Pre-Application Response			Officer:	Stephen Kilmartin
Description:	Phase 2 Lawsonsteads			 Ribble Valley Borough Council www.ribblevalley.gov.uk
Application Ref:	2018/ENQ/0002	Case Officer:	S.K	
Response Ref:	2018/ENQ/0002/UD/01	Issue Date:	22/08/17

General Observations:	
1.1	<p>The observations contained within this response are made in relation to the following submitted information:</p> <ul style="list-style-type: none"> • Pre-Planning Application Document • Proposed Site Layout AA7403 1002 Rev: G • AA7403/SK/04 Site Layout (Plot Numbers) received 22/08/18
Highways Issues:

HOUSE TYPE A (5B8P)

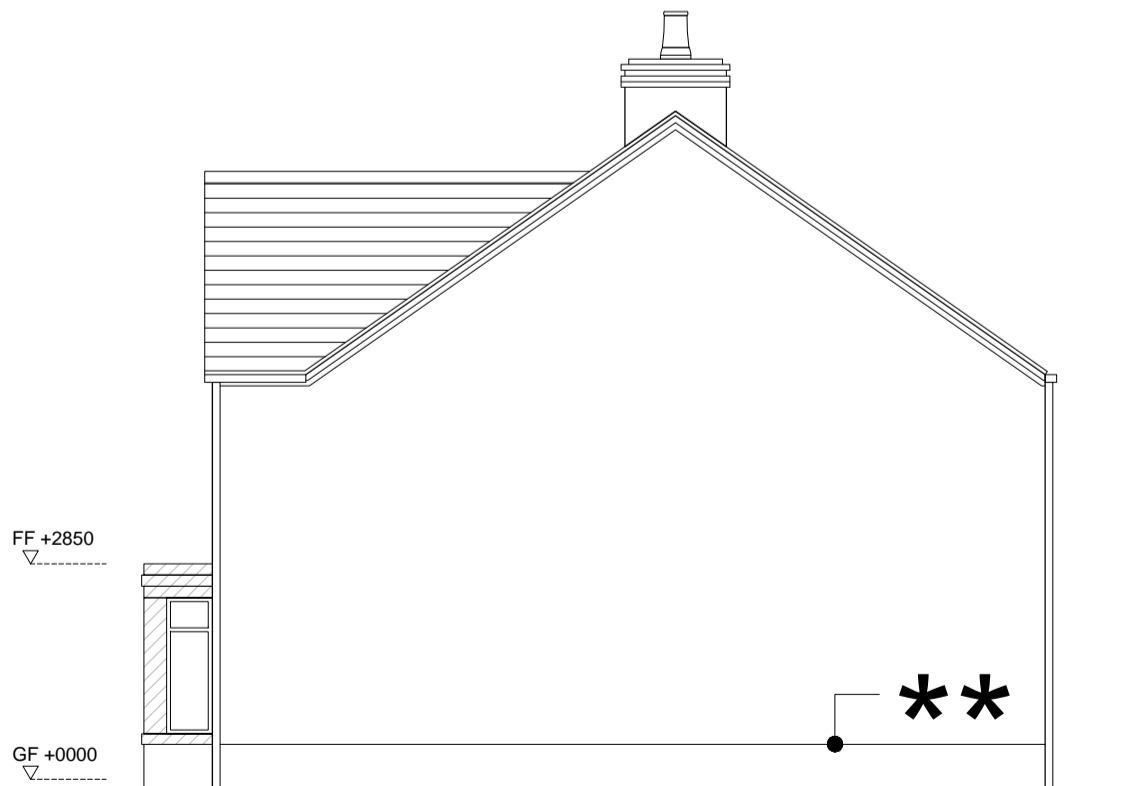
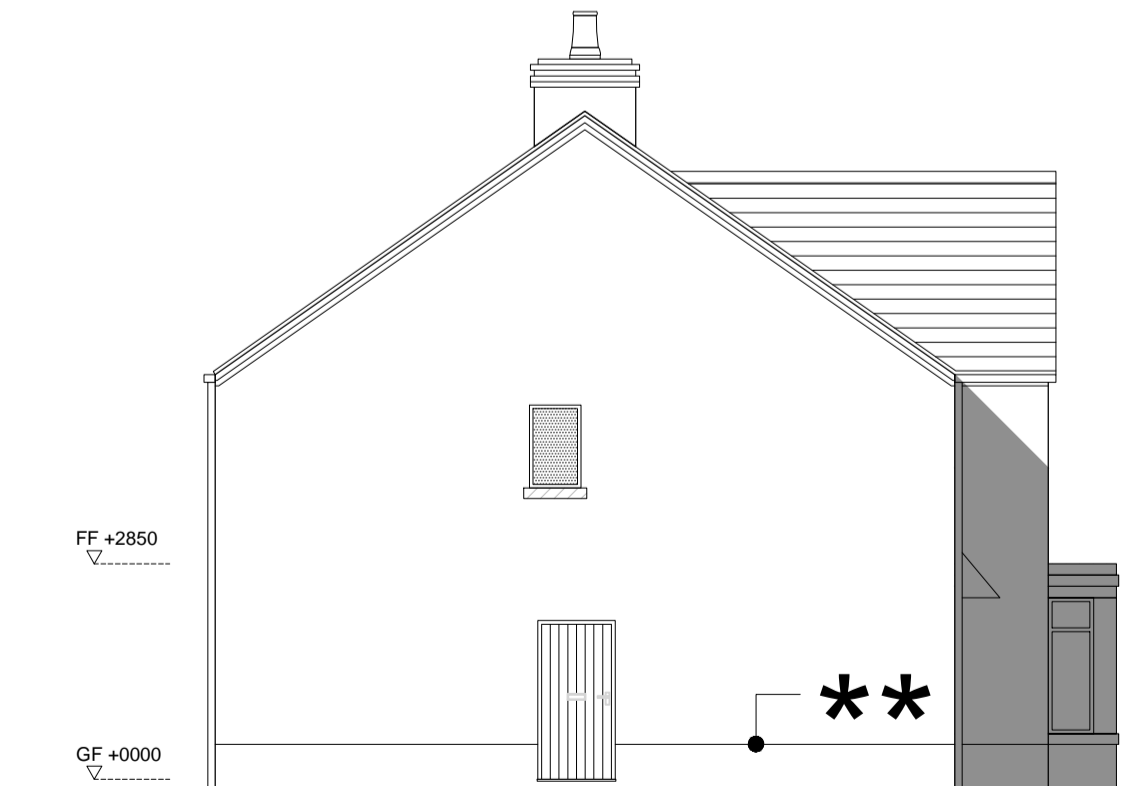
- I have concerns relating to the orientation and configuration of plots 151 and 152 – not only in respect of one another but also in respect of plot 151 and its relationship with the adjacent existing western boundary.
